Consultation Response from: KC Environmental Health (Pollution & Noise Control)

2026/90296 - Green Lane Motors, 14, Wormald Street, Millbridge, Liversedge, WF15 6BE

Discharge of details reserved by condition 5 (noise) on previous permission 2019/93965 for variation of condition 2 (plans) on previous permission 2018/91150 for erection of 3 dwellings

Date Responded:
Wednesday, 03 June 2026

Figure 2.1: Locations of Monitoring Positions

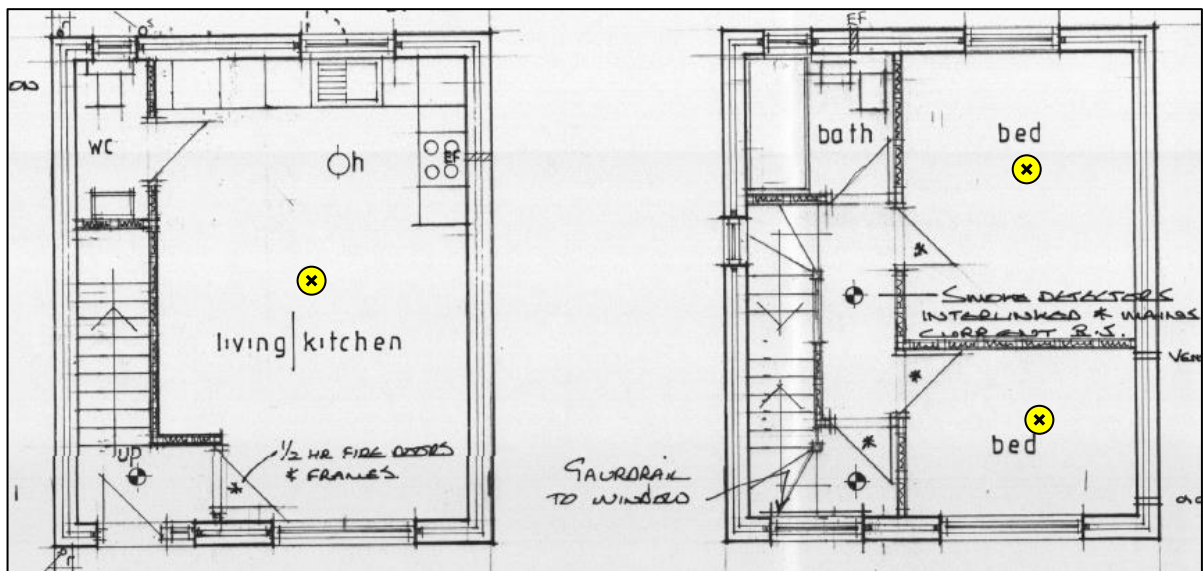
The Noise Validation Testing included two noise measurements undertaken in the bedrooms of one of the flats to determine internal noise levels in bedrooms. The noise measurements confirm that internal noise levels have met the internal design criteria specified in BS8233:2014.

The submitted Noise Validation Testing Report, Ref: NVT-12484-26-12760-V1, dated 29th January 2026, prepared by Environmental Noise Solutions Limited satisfies the requirements of condition 5, which may be discharged.
